5 July 2019

State Significant Development proposal- 657-769 Mamre Road, Kemps Creek

Greg Woodhams
Executive Director, City Planning Projects

1 SITE PLAN (WAREHOUSE 1A, 1B, 2, 3A, 3B, 4)
1: 1000

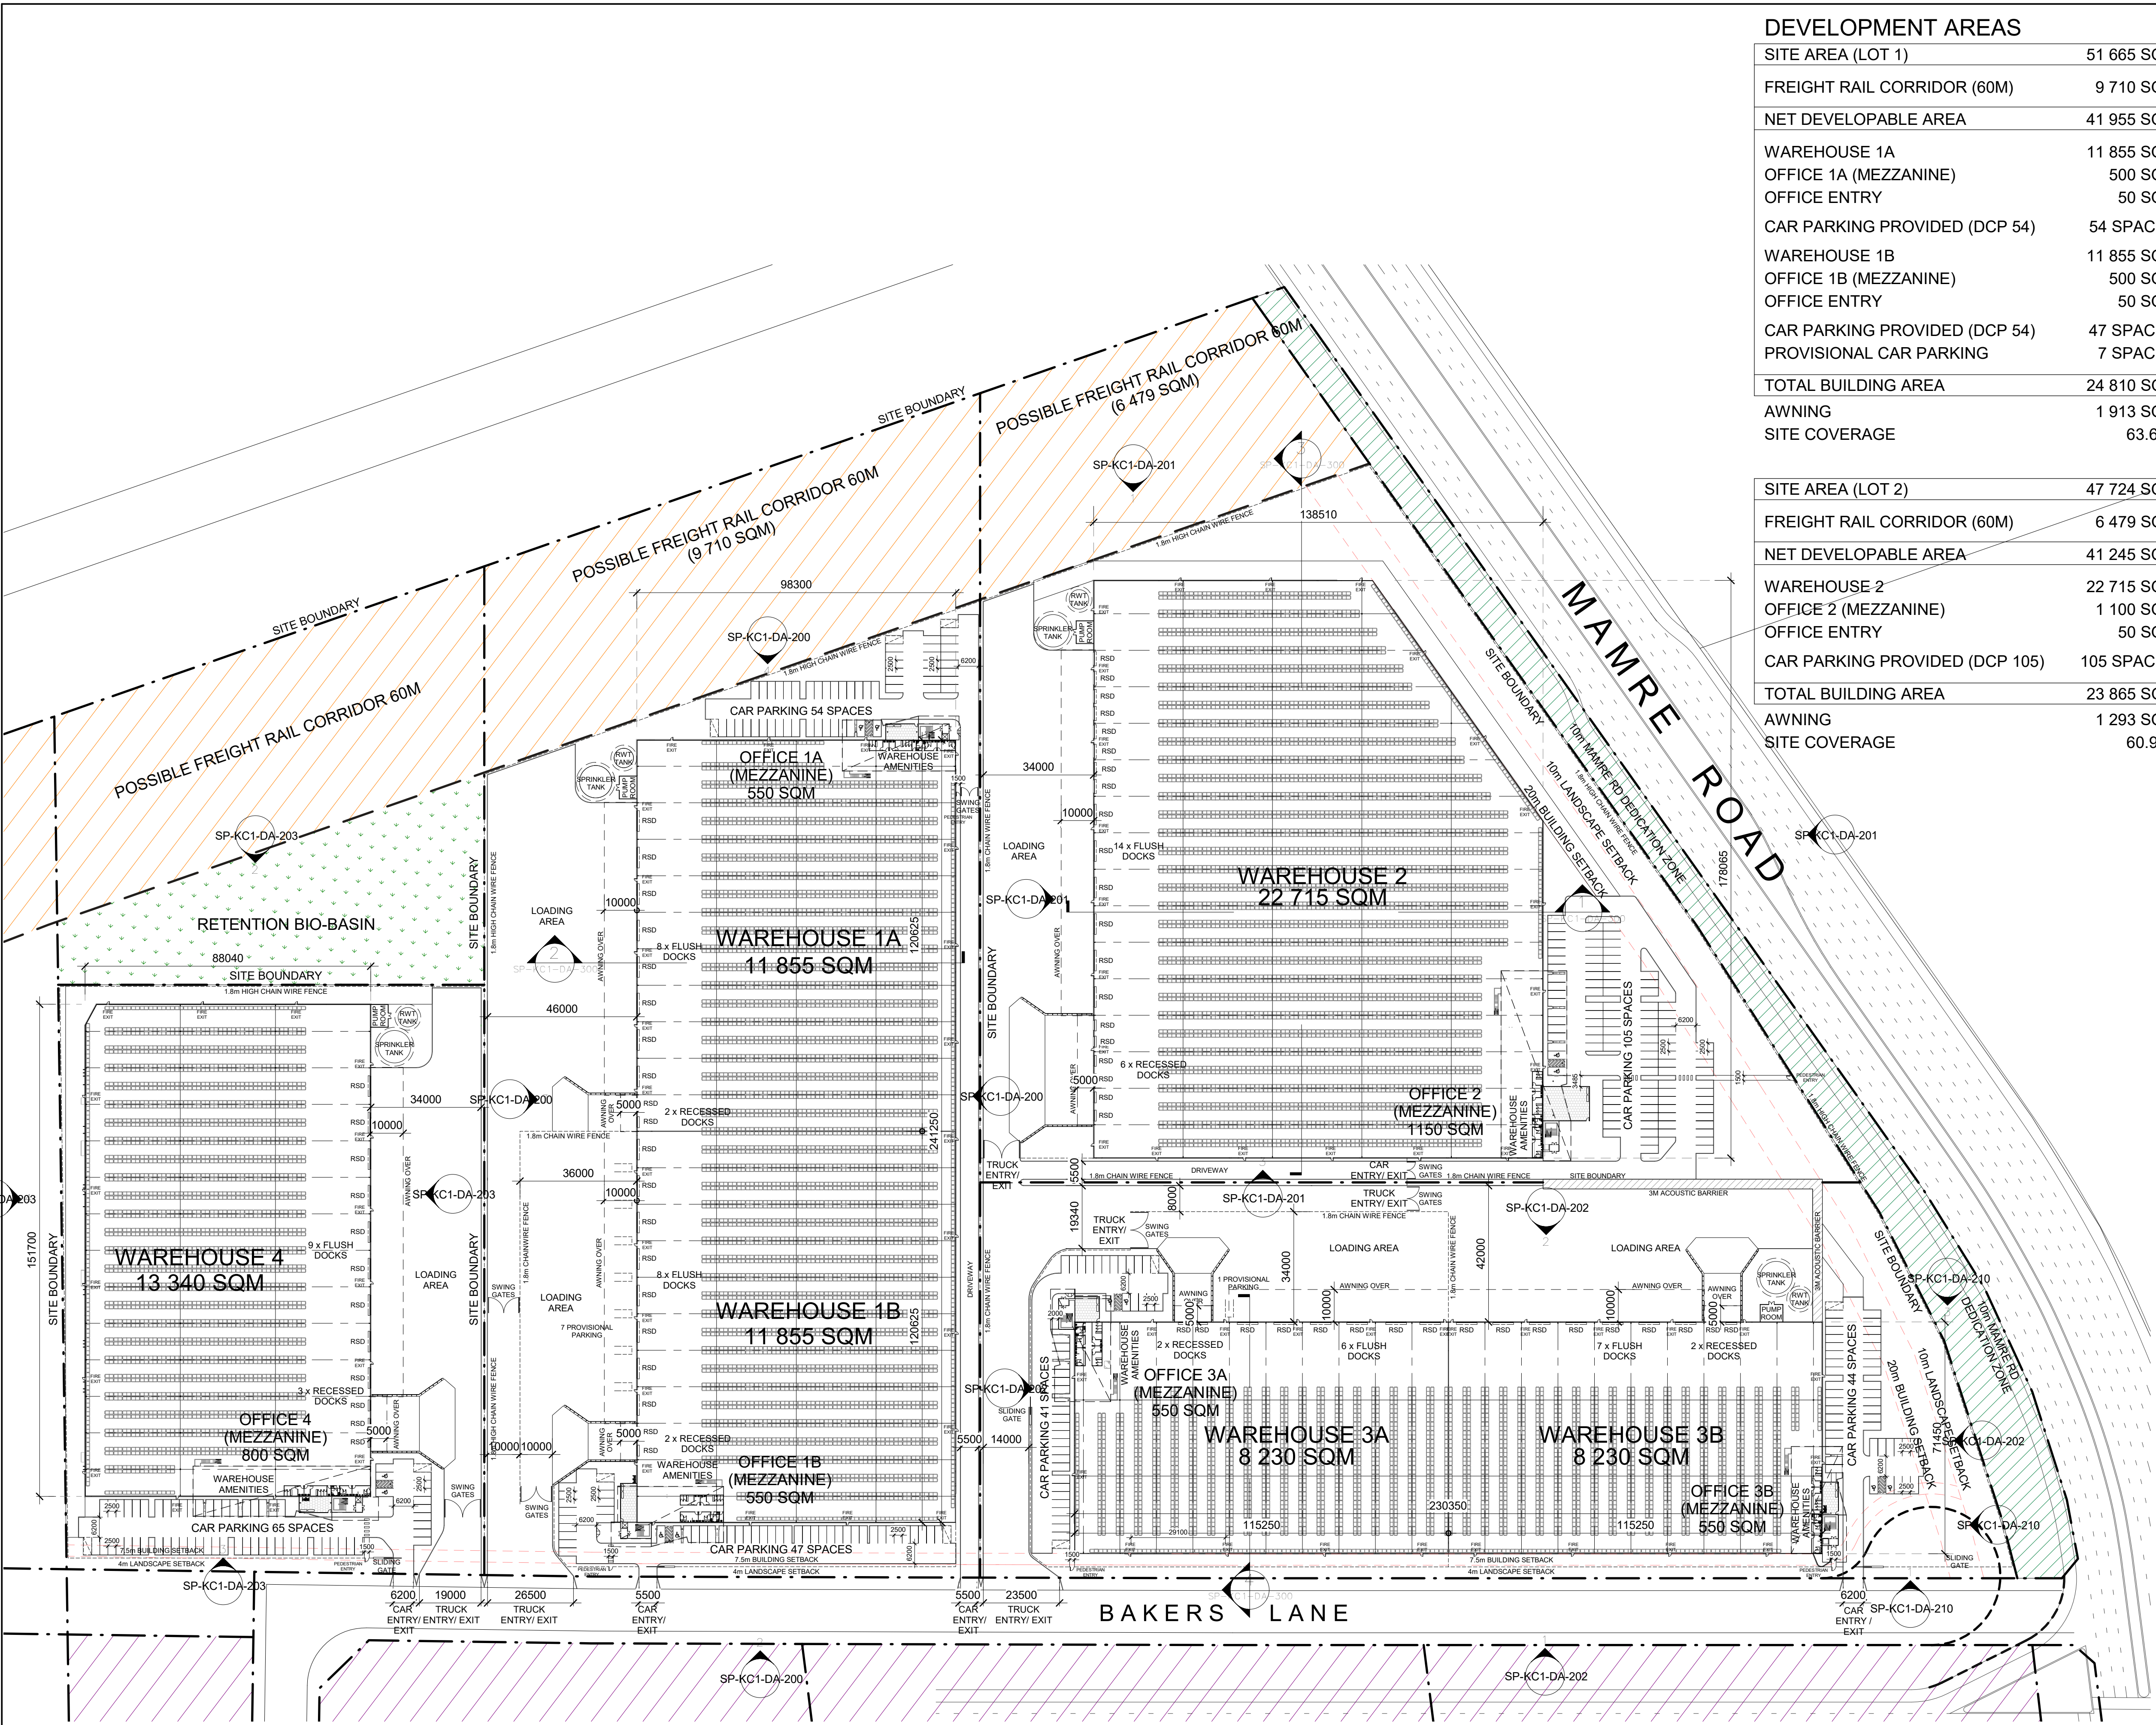
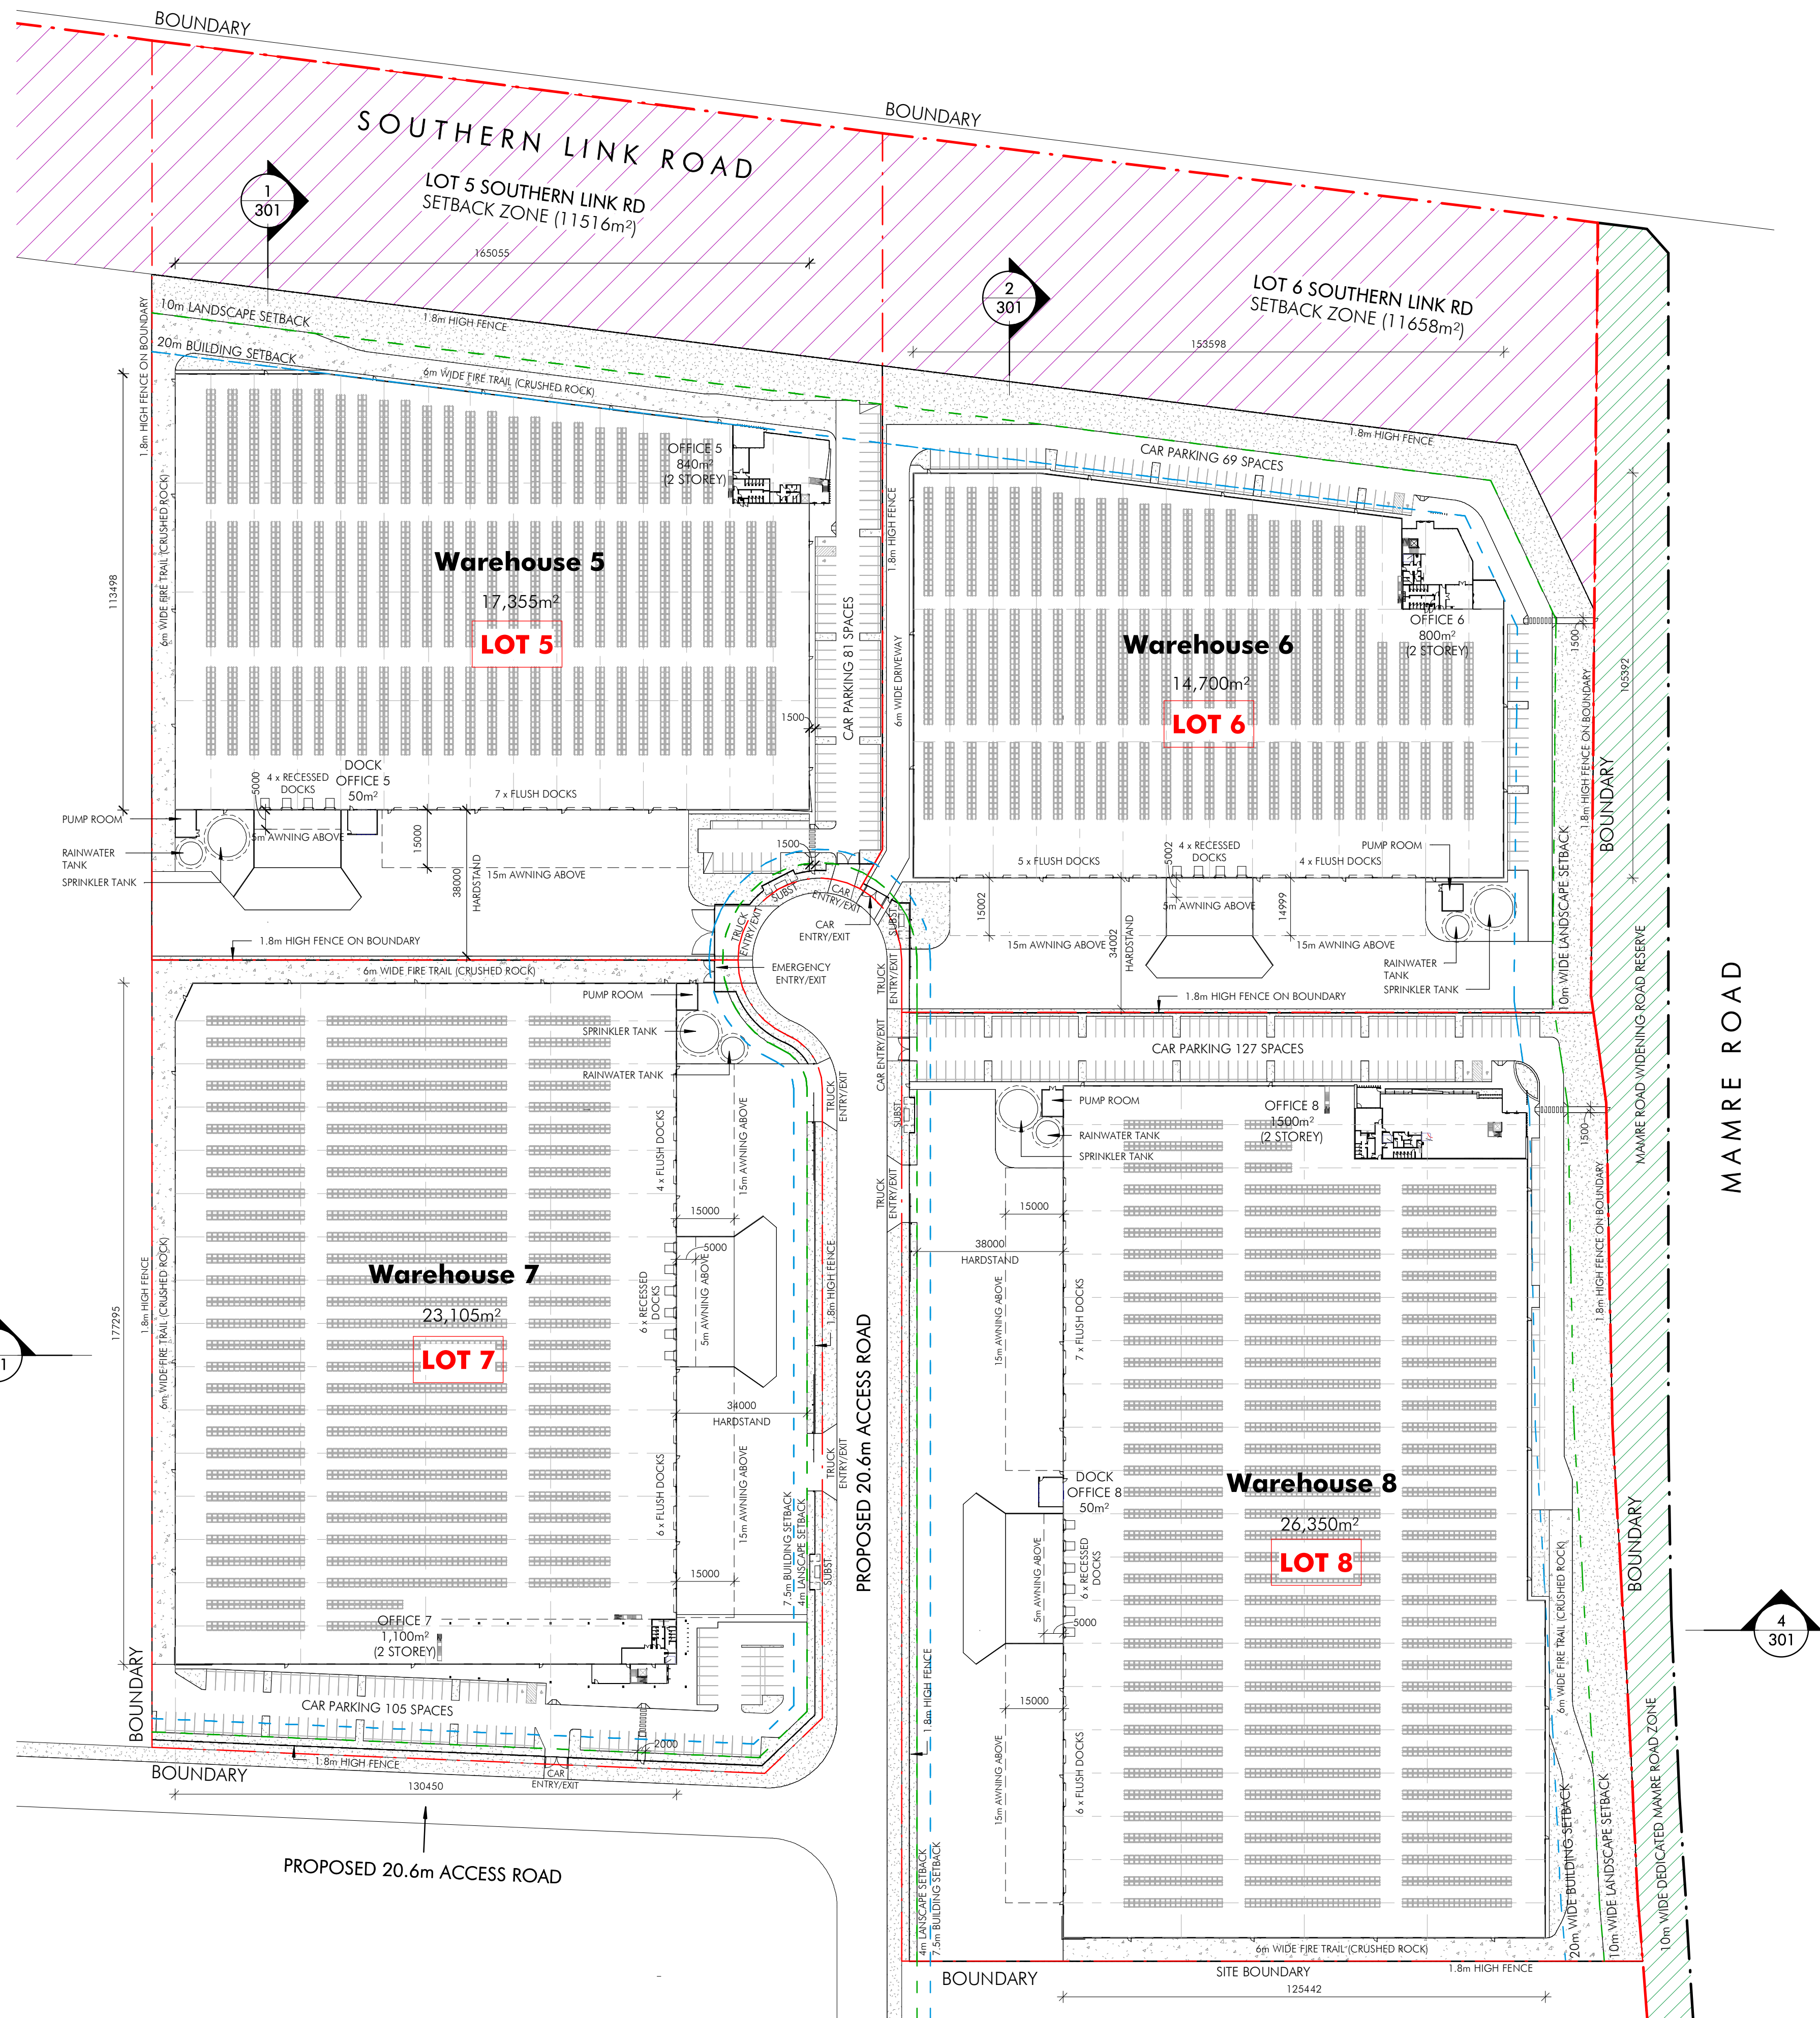
The subdivision plan proposes filling the entire PMF area, as well as the majority of the 1:100-year flood area within the subject site. This would locate urban development within the South Creek Precinct identified in the Aerotropolis Stage 1 LUIIP as non-urban, recognising its important role as part of the South Creek Precinct (refer Figure 16 on page 92 of the EIS). In addition to extinguishing a large area of potential Parkland, it would effectively sever the South Creek Spine, the central liveability element of the Parkland City, disconnecting the Parkland Spine within the LUIIP area from the Parkland Spine to the north within the Greater Penrith to Eastern Creek (GPEC) Investigation Area (refer figure 17 on page 94 of the EIS).

The extent of fill and potential urban development may significantly reduce the potential to *protect and improve the health of waterways; GSRP Objective 25*. Sydney Water is currently undertaking investigations examining the requirements to achieve sufficient flow in the waterways including South Creek. The quantum of fill proposed may significantly impact this work and is premature.

The proposal envisages the removal of all remnant vegetation including tree canopy outside from the 11-hectare area to be revegetated, all of which is located within the 1:100 flood zone (which also includes proposed detention basins that it is assumed will exclude any significant canopy within basin areas should they be permitted in the floodplain). This is not consistent with *GSRP Objective 27; Biodiversity is protected, urban bushland and remnant vegetation is enhanced*.

Notwithstanding the comments above with respect to the extent of fill, the subdivision layout outside the 1:100 itself could be amended to preserve existing trees to create a superior

environment in keeping with the Parkland City objectives, consistent with GSRP *Objective 30: Urban tree canopy cover is increased*.

The street plan should create a permeable and walkable network including public access along the South Creek edge, connected more broadly to the Green Grid, currently being developed as part of the studies noted above. The current plan consists of a number of culs de sac and does not appear to include public access along the creek edge. This is not consistent with GSRP *Objectives 31 and 32: Public open space is assessable, protected and enhanced; the Green Grid links parks, open spaces, bushland and walking and cycling paths*.
